WEST SUSSEX COUNTY COUNCIL CONSULTATION

TO:	Arun District Council FAO: Simon Davis
FROM:	Stephen Gee WSCC – Highways Authority
DATE:	14 September 2026
LOCATION:	Land East of Wandleys Lane Fontwell
SUBJECT:	WA/51/26/RES Approval of reserved matters following the grant of outline planning permission WA/35/23/OUT, for the construction of 95 No. new homes, access, new pedestrian and cycle links, open space, landscaping, habitat creation, drainage features and associated groundworks and infrastructure, including details relating to the Sensitive Lighting Strategy, POS details and Part M Compliance. This application is in CIL Zone 3 and is CIL Liable as new dwellings. Amendments made in response to Ecology, Highway and Drainage Comments.
DATE OF SITE VISIT:	n/a
RECOMMENDATION:	Advice / No Objection

Drawing Title:
SITE LAYOUT
AREA PLAN

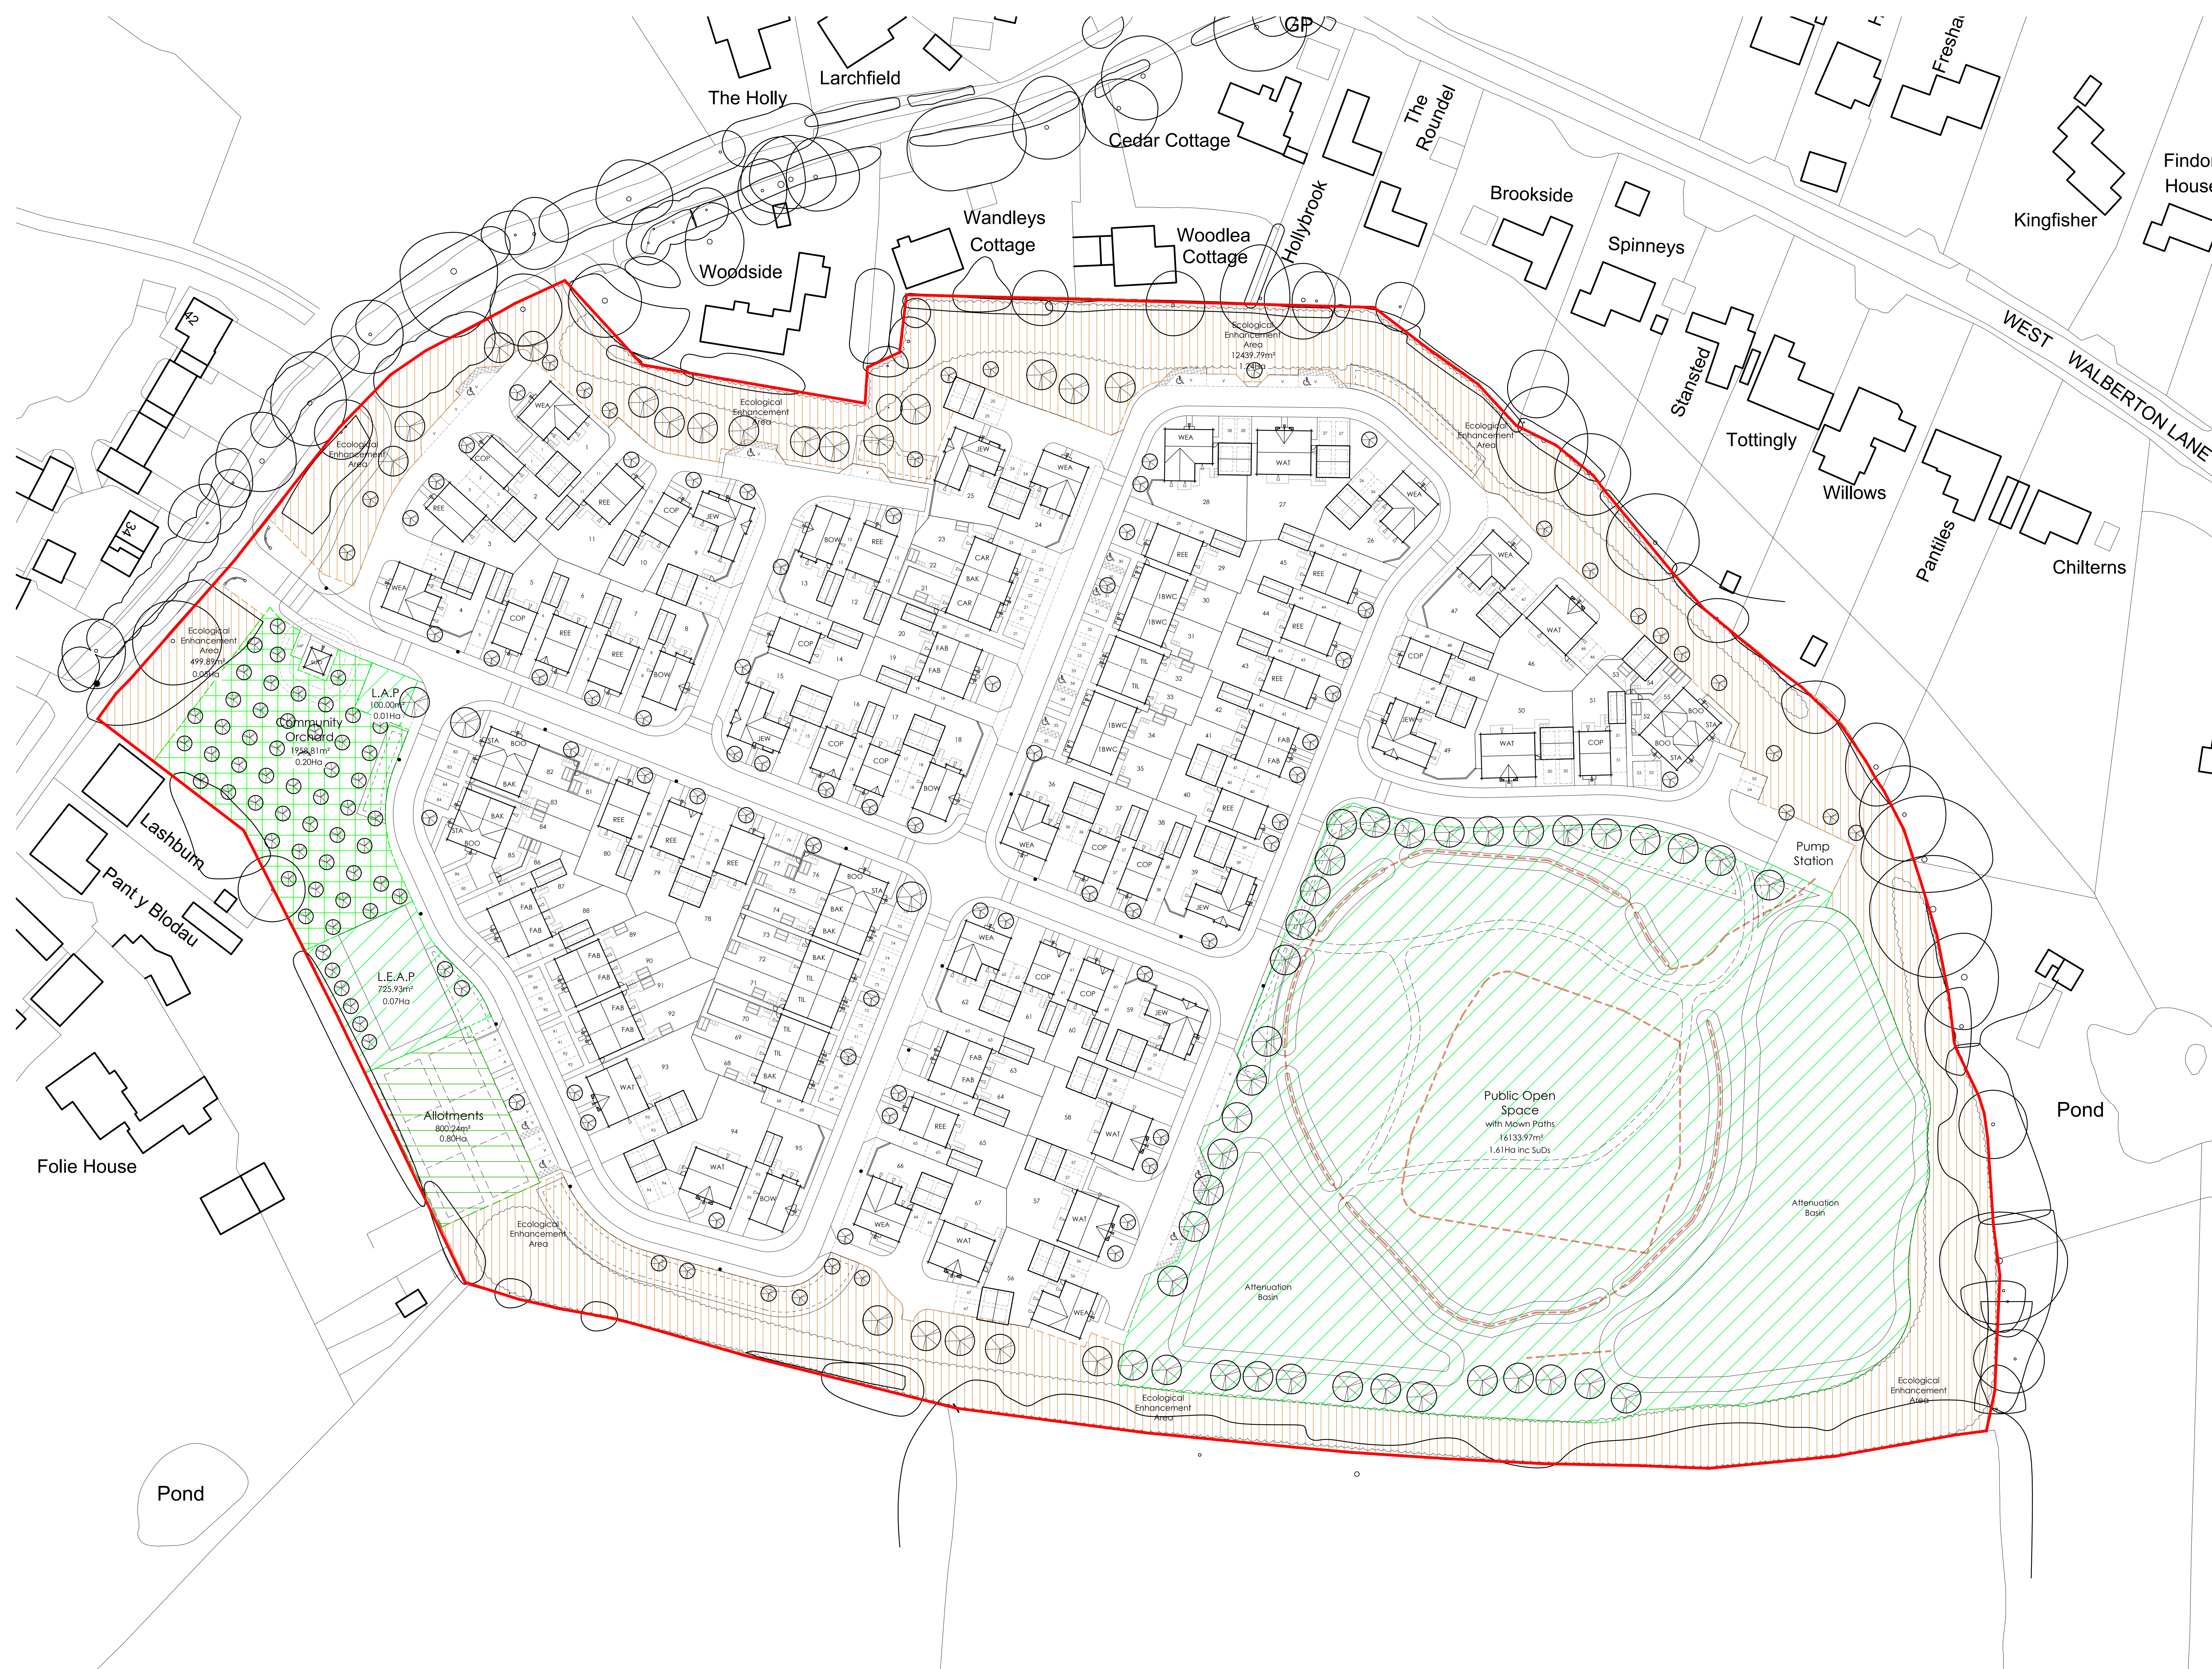
The applicant identifies that the driveway lengths are as a consequence of ensuring dwellings comply with building regulations and design requirements. The LPA should consider the potential design implications of the parking and its accordance with Aruns parking standards.

Two spaces have been relocated from the peripheral locations opposite plots 27 and 28 to adjacent to plots 15 and 18. The applicant states that further relocations can not be undertaken without compromising visibility splays.

Visibility splays based on a 20mph design speed have been provided and are acceptable.

The applicant has considered the potential for additional pedestrian links but identifies that they would encroach on the Ecological Enhancement Area, given alternative routes (albeit slightly longer in distance) are available no further concern is raised.

No objection is raised to the application. The LPA should consider the implications of the design of the driveways, if possible, design solutions could be secured and if not its implications when considering the requirements of the Arun Parking Standards.
